**WEST SUSSEX COUNTY COUNCIL**  
**STRATEGIC PLANNING CONSULTATION**

**SUBJECT:** R/105/15/PL-New area of interlocking grass-block system to North-East to provide for relocation of minibus parking (partial resubmission following R/307/14/PL).

Princess Marina House, 61, Seafield Road, Rustington, West Sussex

JOB number:	drawing number:	revision:
2082	(11)001	1
project:	Princess Marina House	
client:	Seaside Apartments	
client:	RAF Benevolent Fund	
title:	Parking Plan	
date:	22/04/15	scale:
	1:100 @ A1	drawn: GT
		checked: CS

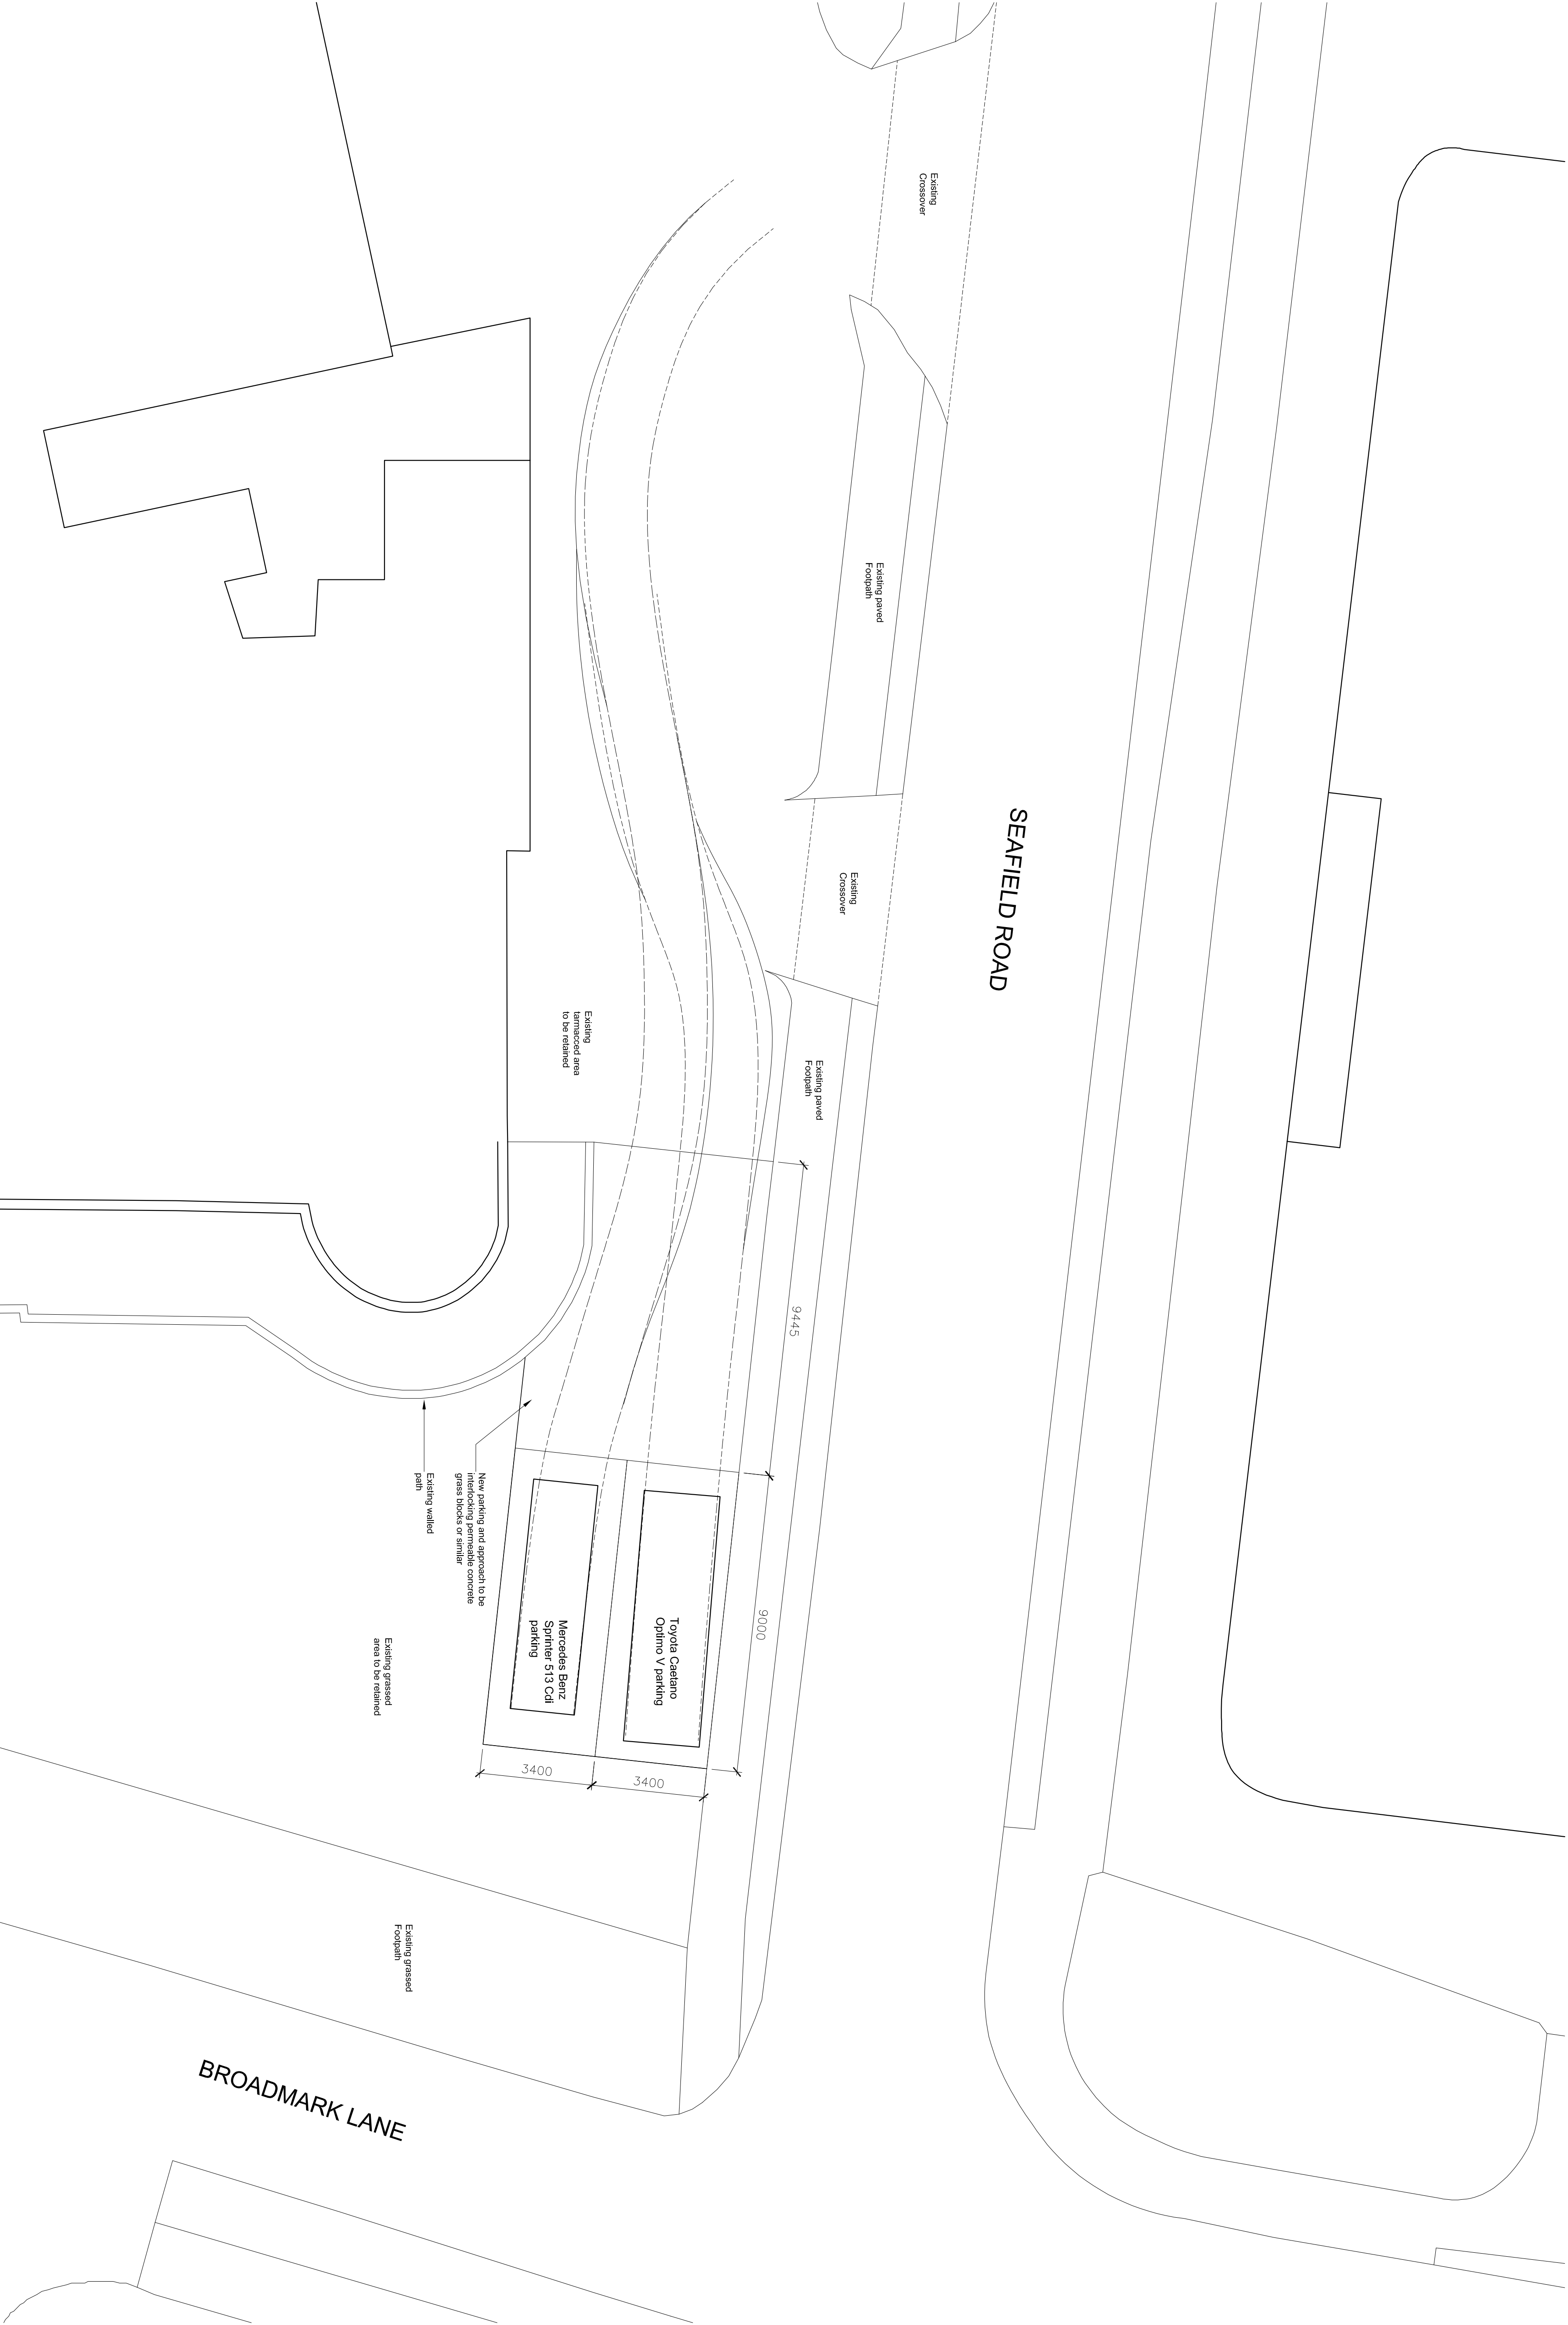
Following our request for further information on parking for larger vehicles such as mini buses in the previous application (R/307/14), the applicant has now provided a revised plan

which includes parking shown via swept path diagrams how a vehicle can safely enter and exit the parking spaces. The other areas of the proposal were commented on in the previous application. The revisions are considered acceptable from the Highway point of view.

If the LPA are minded to approve this application a condition securing the parking spaces at the dimensions stated would be required.
